30 October 2025

TII25-133171

Re: Strategic Infrastructure Development Application for the Garrane Green Energy Project comprising 9 no. wind turbines, grid connection and all associated site works at Ballynagoul, Creggane and Garrane, Co. Limerick

ACP case ref. PAX91.323448

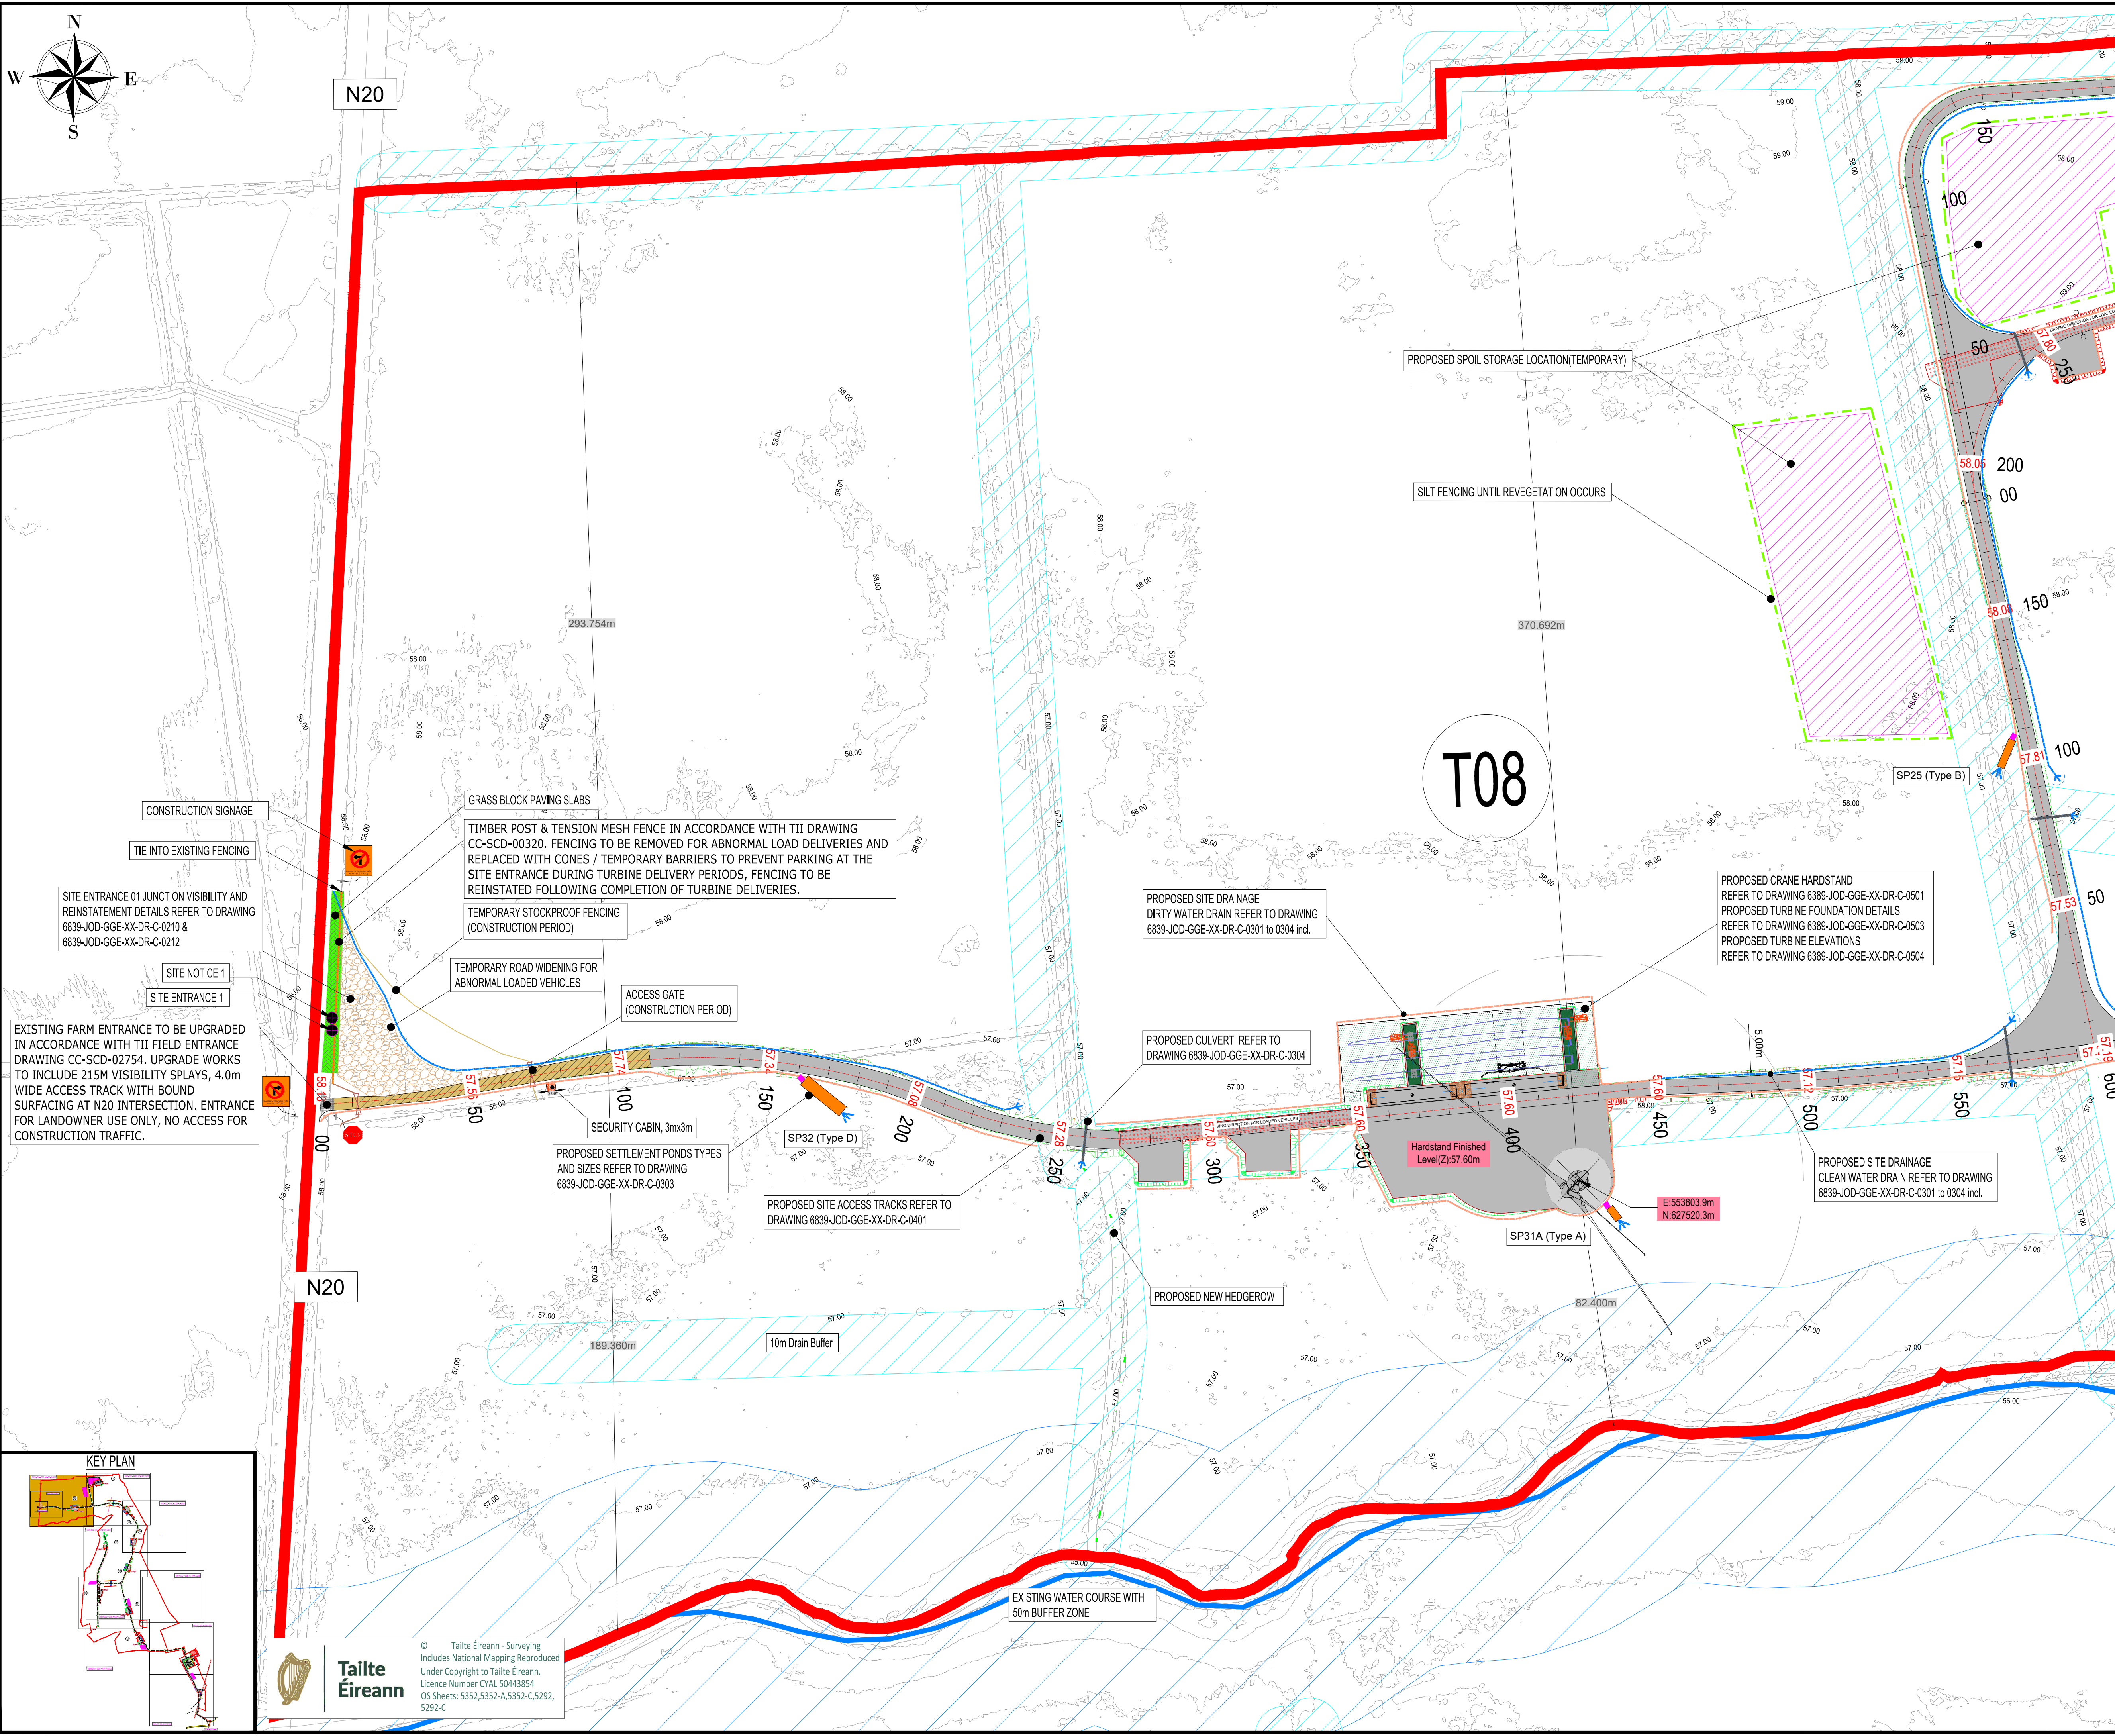
In relation to the subject application, TII notes that proposed Entrance no. 1 to the subject development site is taken directly off the N20 at a location where TII's records indicate a 100kph speed limit applies. Table 17.1 of the EIAR submitted outlines that the proposed temporary access on the N20 will be used for turbine delivery only and that all general construction traffic will access the site via the L1537 local road. Table 17.1 also indicates that roadside screening will be installed post-construction and it appears that the access will revert to agricultural use. Drawing no. 6839-JOD-GGE-XX-DR-C-0 submitted indicates Entrance No. 1 reinstatement details.

TII outlines the following matters for the Commissions consideration in the assessment of the subject proposal concerning the proposed works at Entrance no. 1 accessing the N20, national primary road, at a location where a 100kph speed limit applies;

- The proposed temporary works to the N20 at Entrance no. 1 are for a temporary period only to facilitate turbine component delivery and thereafter temporary works shall be removed and lands reinstated following completion of the construction phase of development in the interests of road safety and adherence to the provisions of official policy.

- The proposed temporary works to the N20 at Entrance no. 1 should be closed off with a temporary safety barrier when not in use for turbine component delivery, as it could be misinterpreted by drivers as part of the roadway. Pending completion of construction, the temporary works shall thereafter be permanently closed and the lands reinstated.

- Any damage caused to the pavement on the existing national road at the access from the N20, national road, due to the turning movement of abnormal loads (eg. tearing of the surface course) shall be rectified in accordance with TII Pavement Standards and details in this regard shall be agreed with the Road Authority prior to the commencement of any development on site.

- It is noted that a Road Safety Audit (RSA) is included in Appendix 17.5 of the EIAR submitted and Entrance no. 1 has been included in the assessment. All recommendations of the Road Safety Audit shall be incorporated into final designs for construction and the requirements to implement the recommendations of the Road Safety Audit included as a condition on any permission granted.
- In the interests of road user safety, all works to the national road shall comply with TII Publications (formerly NRA DMRB); technical design standards for national roads.
